The Member-Secretary,
Chennai Metropolitan
Development Authority,
No.8, Gandhi-Irwin Road,
Egmore, Chennai-600 008.

Letter No. C3/ 1083/99

Sub: CMDA - Planning Permission - Multi-
Storeyed Building - Proposed revision of
residential designated house, Guest house
and Officers Club at S.No.134Pt. 135Pt.,
136Pt. 137Pt. 143Pt. 144Pt. 145Pt. 146Pt.
147Pt. 156Pt. 160Pt. 161Pt. & 253Pt. of
Padi village, site No.R12-A1 R-14 and R-19,
Park Road, Anna Nagar, Western Extension -
Chennai.

**SITE PLAN (REVISED)**

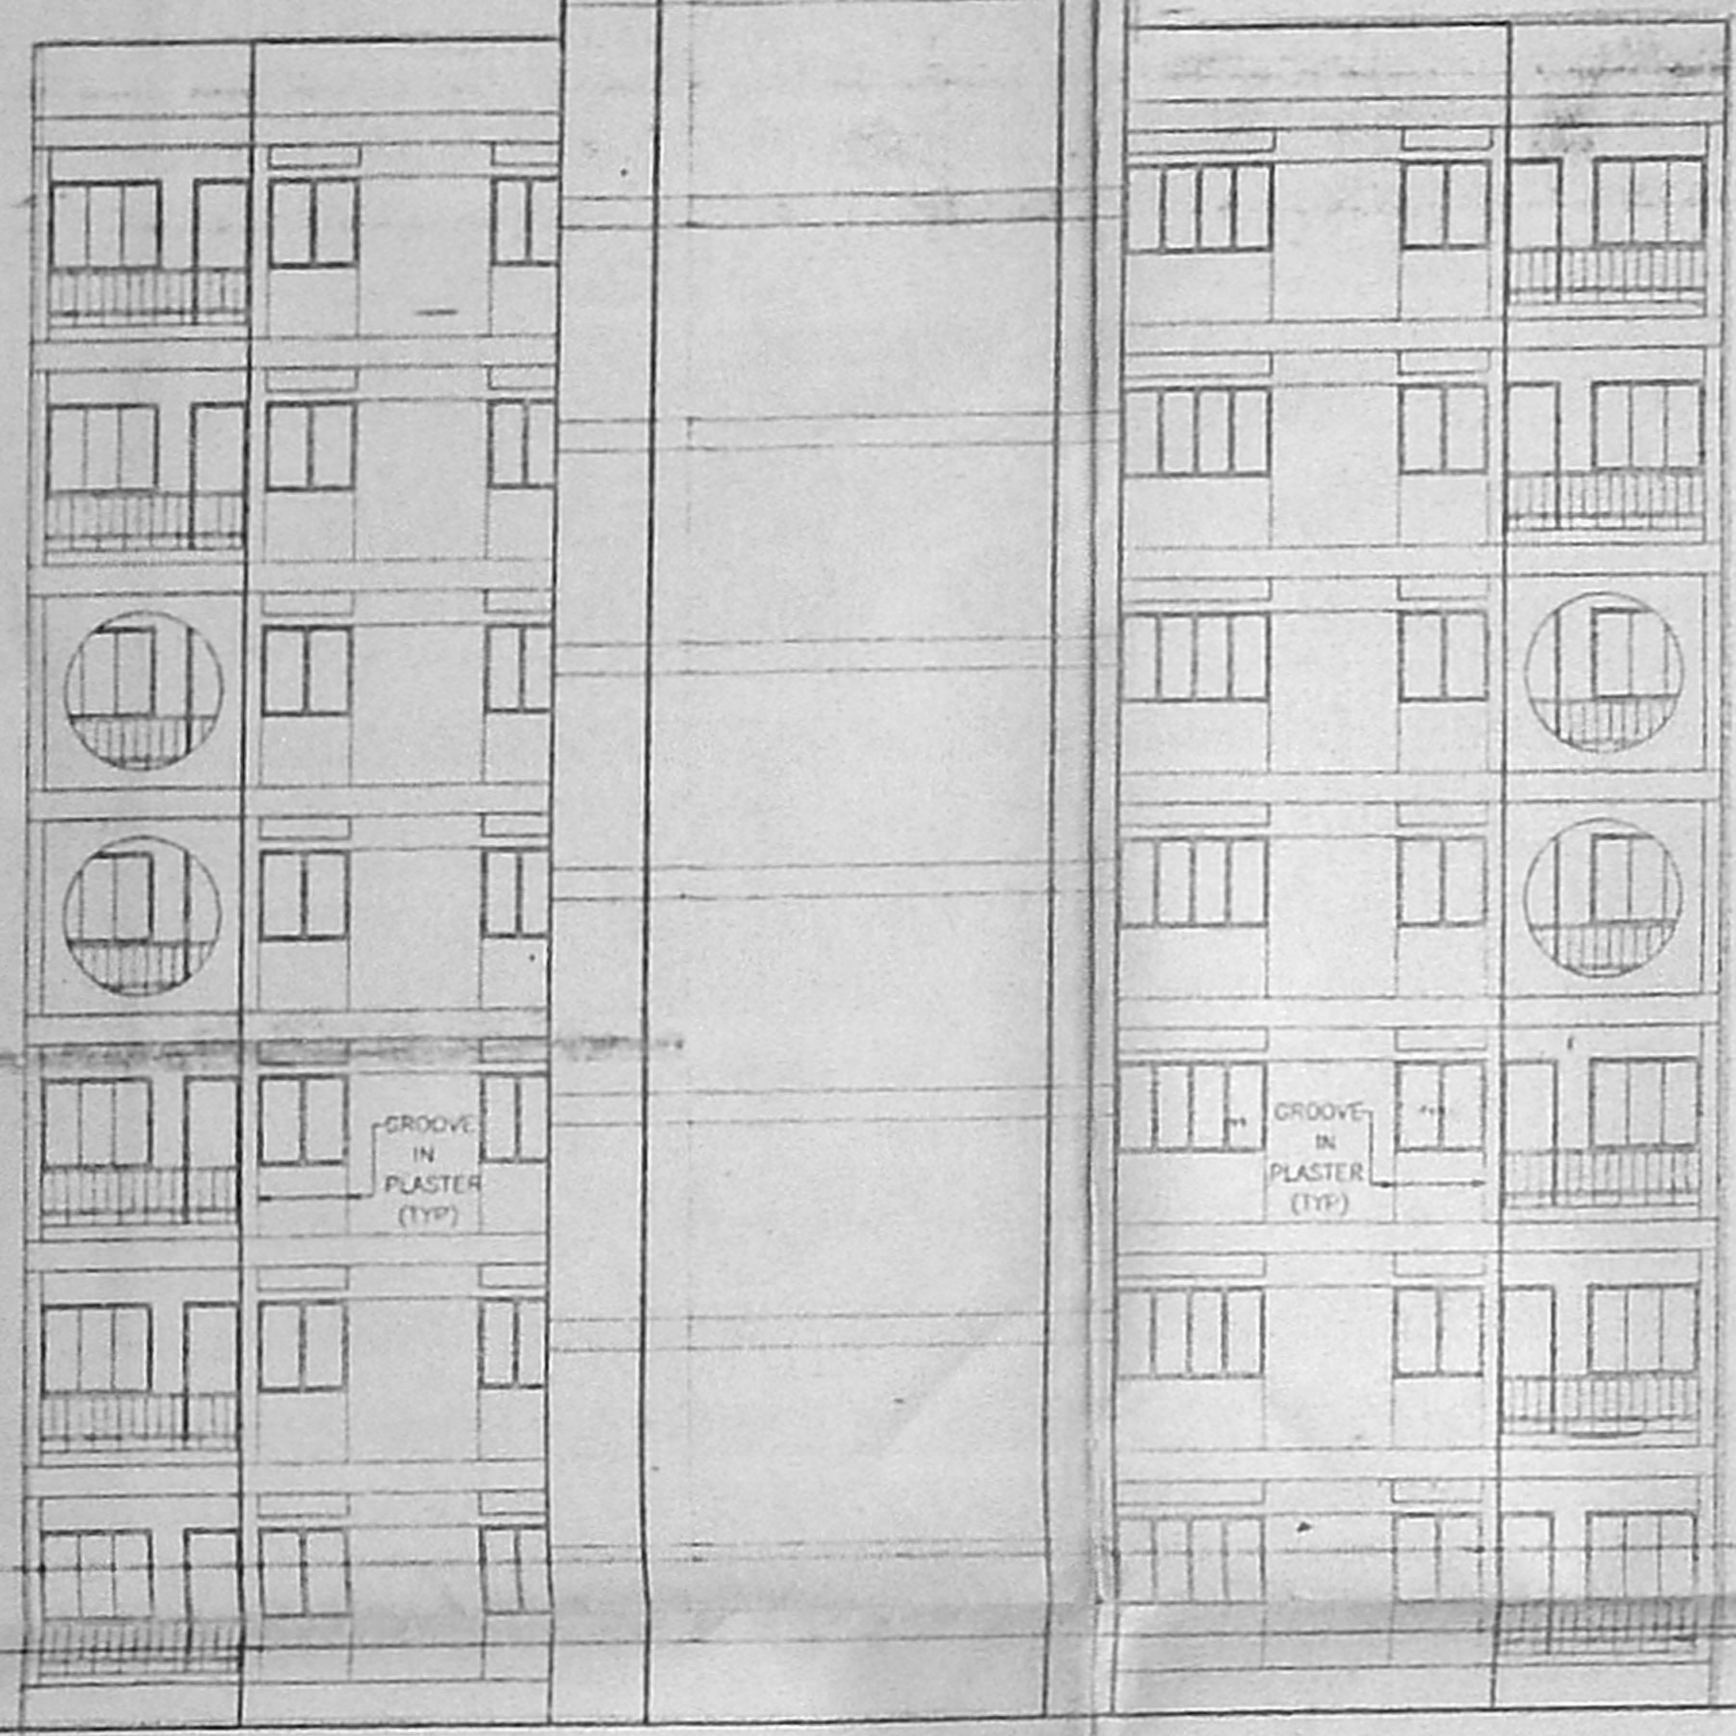
- xv) To furnish 5 sets of revised Plans showing Parking arrangements as per G.O.No.56, HAUD Dept., dt.22.2.99 and also obtaining Architect & Engineer with Class.I Licensed Surveyor in all the plan.**
